SUBJECT: **TECHNICAL REVIEW 1**
PROJECT NAME: **Margaret Estate Apartments**
PERMIT NUMBER: **PA 23-027**

On behalf of Mr. Benny Kim, we are resubmitting revised Civil Plans for the above referenced project in accordance with your Technical Review comments dated December 26th, 2023.

LANDSCAPE PLANTING PLAN
FILE 2241
LI.00

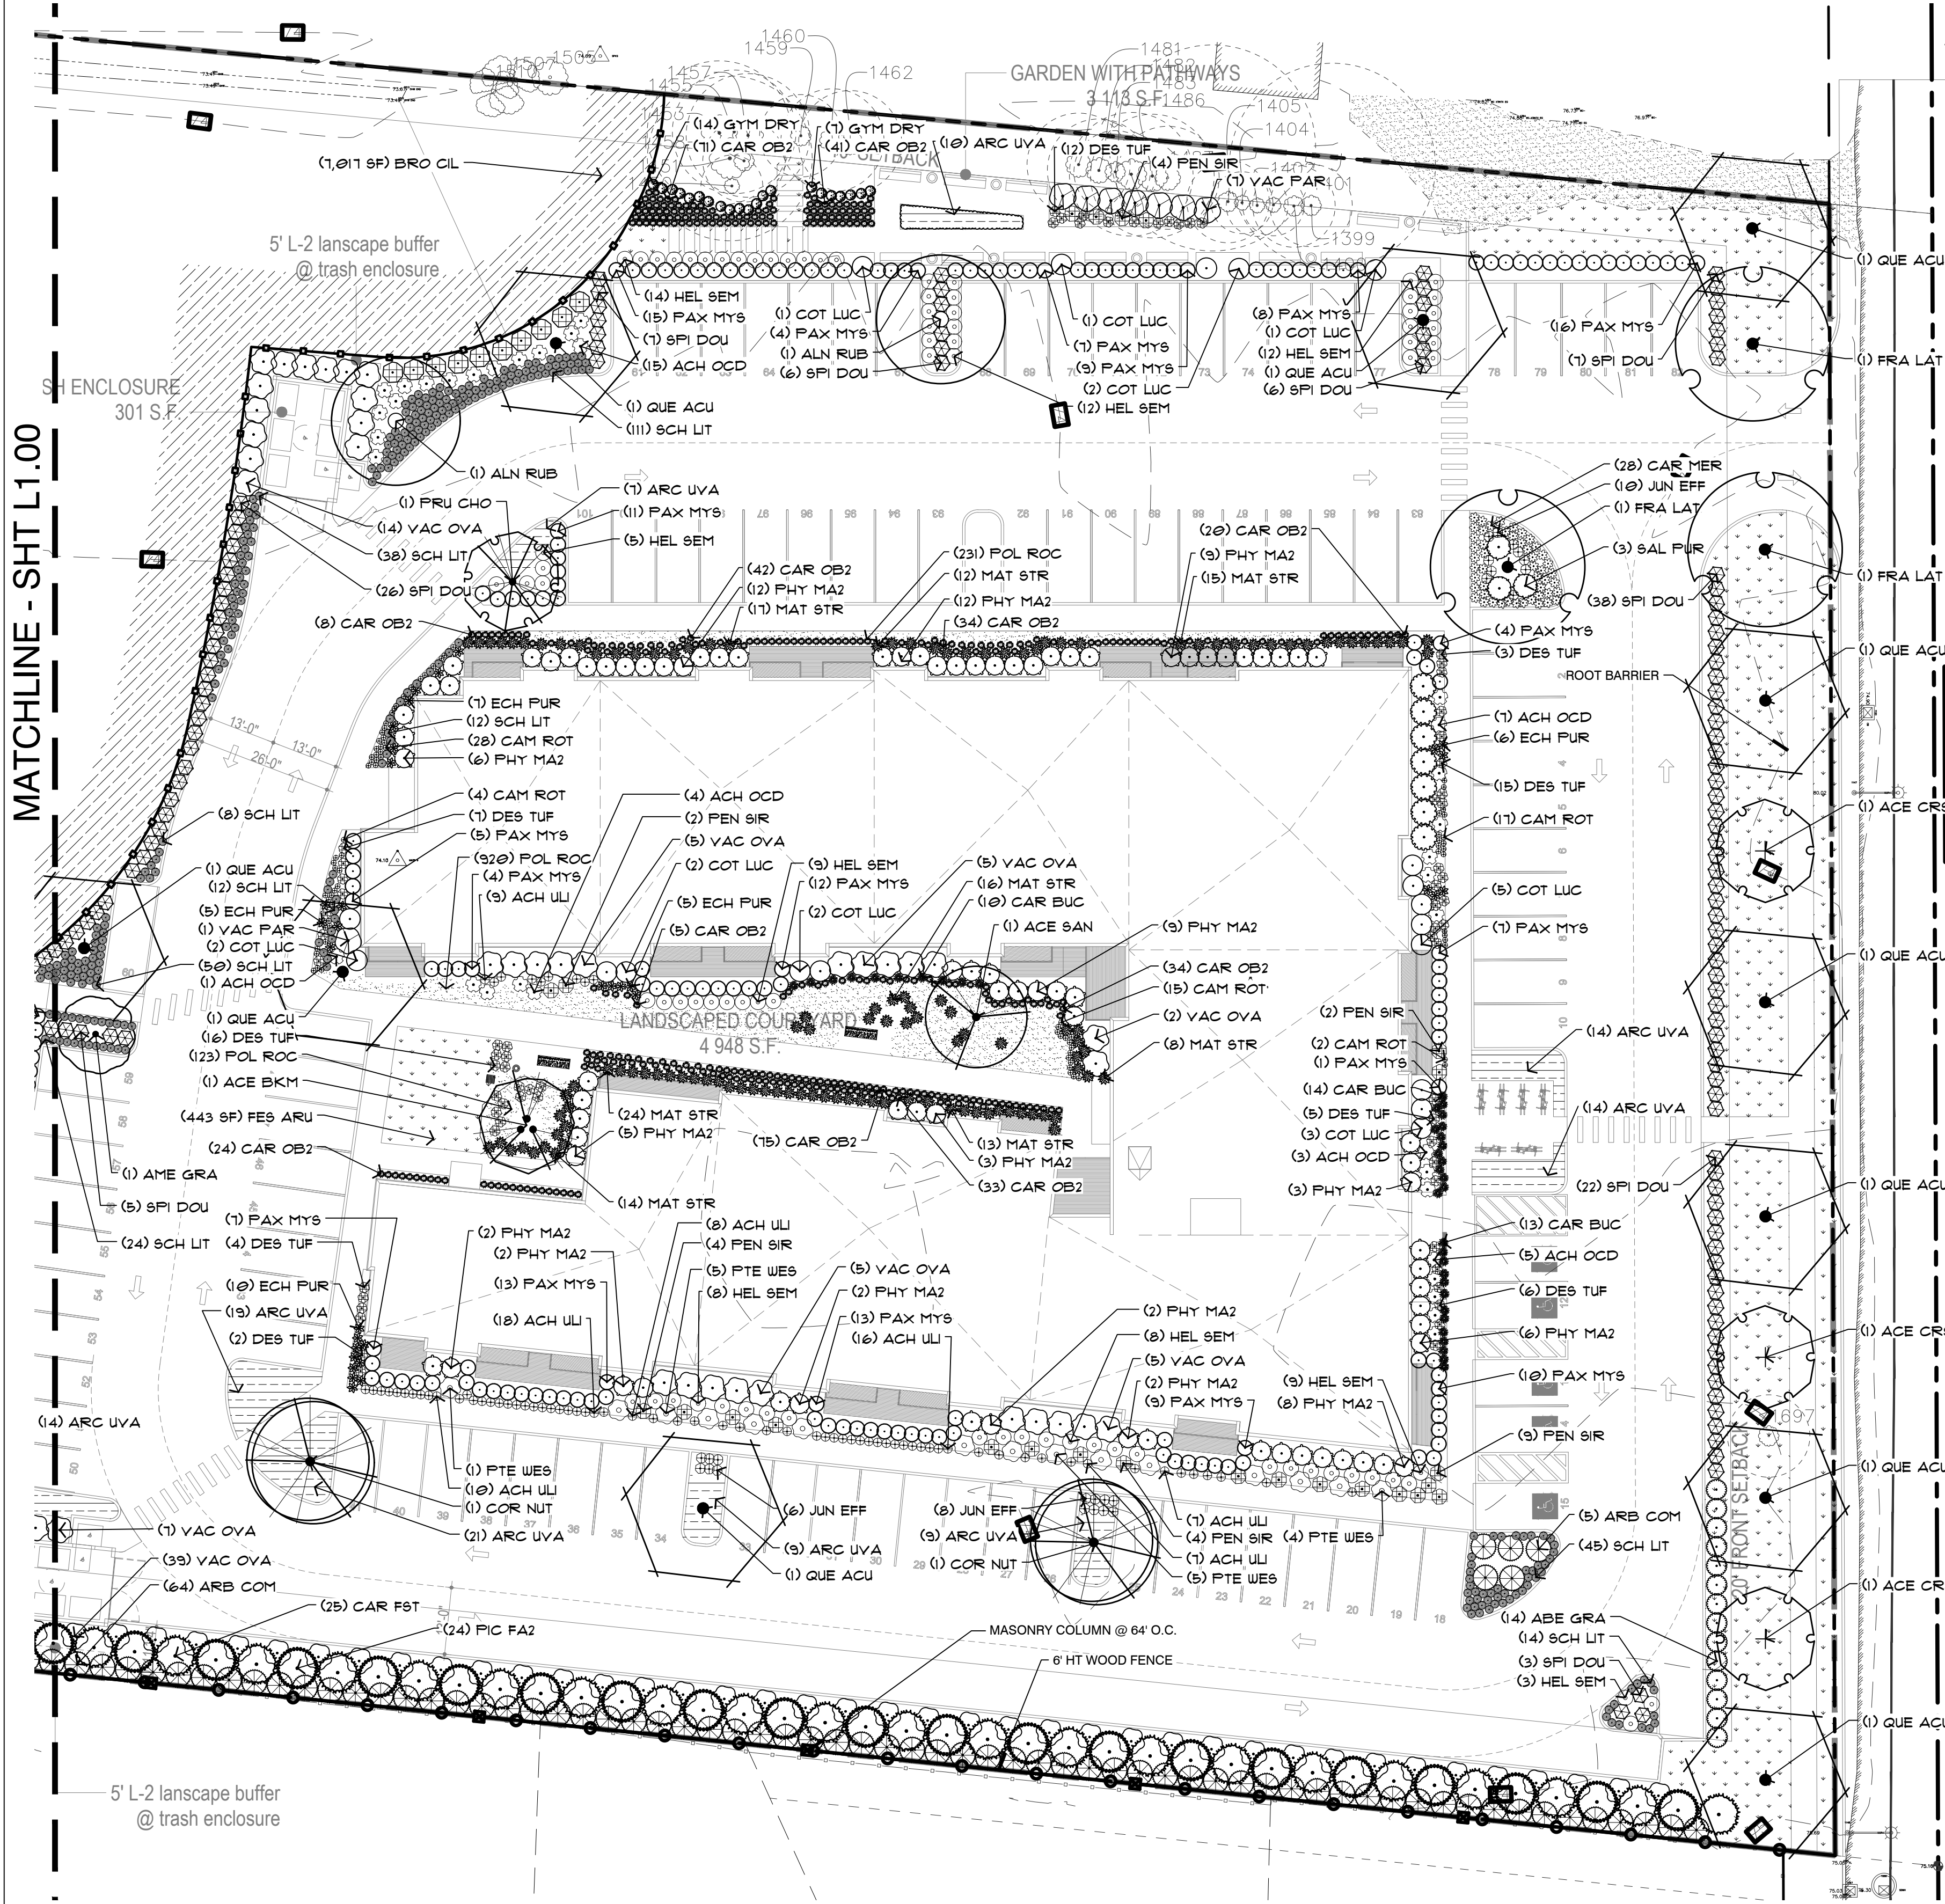
- f. Ground cover.
- a. A 10-foot wide, type L-1 buffer and six-foot sight obscuring fence is required along the southern and western property boundary. Please see L1 standards below and revise accordingly. Please provide detail of the required fence.
Fence has been added along with type L-1 buffer requirements.

- d. No parking stall shall be located more than 45 feet from a landscaped area. It

appears that additional landscape areas are needed in the parking areas along the east, south, and north of the building.

- e. A minimum 5 foot wide L2 landscape buffer shall be provided on all sides of dumpster enclosure.
L2 buffer has been added.
- f. Street trees are required to be planted along 55th Avenue NE and comply with the following:
 - i. Street trees shall be planted 5 to 8' behind the sidewalk and 30 feet on center to create a continuous canopy.
 - ii. Street trees shall meet the most recent ANSI standards for a 1 ½" caliper at the time of planting and shall be spaced to provide a continuous canopy coverage within 10-years.

Landscape areas have been added to noted areas.

Street trees have been changed to meet this requirement.
